From: Laura Gibbons <laura.gibbons@adur-worthing.gov.uk>
Sent: 25 August 2020 14:15
To: Planning.Responses
Cc: Michael Eastham
Subject: BN/84/20/PL

Thank you for consulting us on this Section 73 application to vary the previously approved layout.

SITE LAYOUT P19-0723_10P

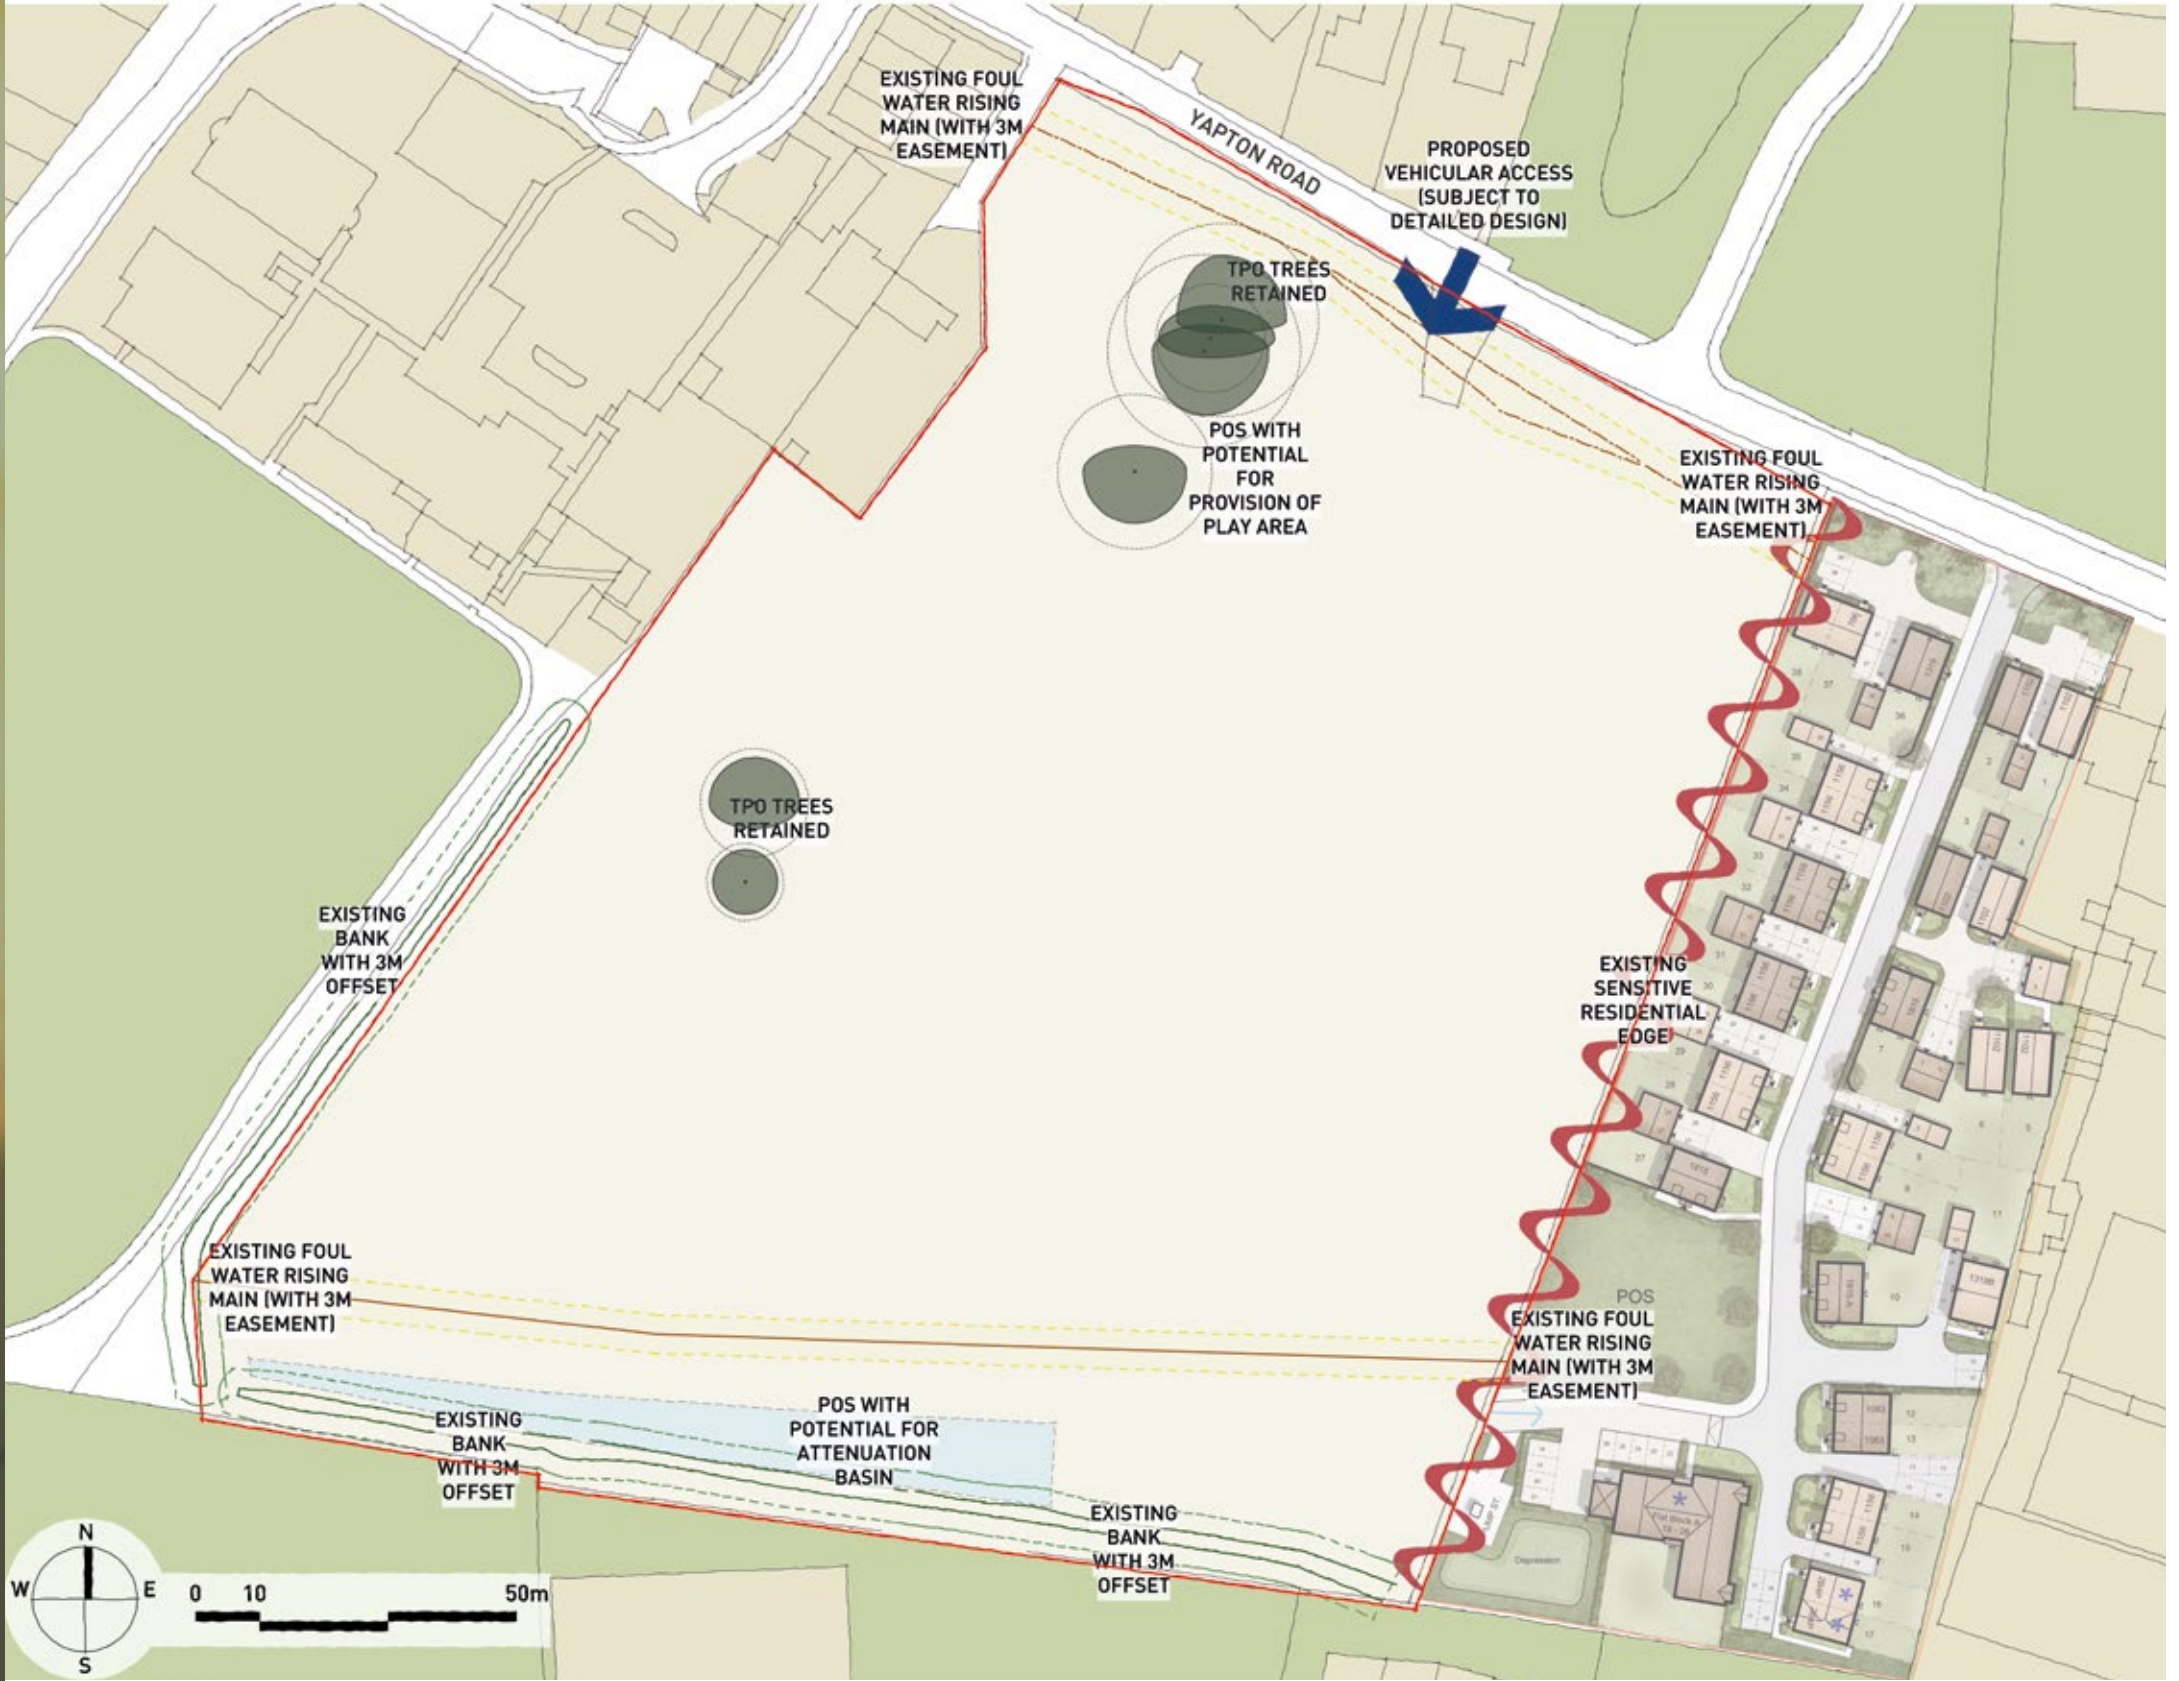
The proposed layout appears to completely ignore the approved drainage scheme, with areas of permeable paving lost and a building and parking area proposed where the attenuation basin is located.

It is also evident that dwellings and structures are positioned close to ordinary watercourses in this proposed layout, a minimum of 3m must be provided between top of bank of watercourse and obstructions.

We do not believe there is adequate space within the proposed layout to drain the site and not increase flood risk. To overcome this objection the applicant will have to supply full drainage details (to the level submitted for the recent discharge of conditions application) at this stage, details cannot be left to post determination.
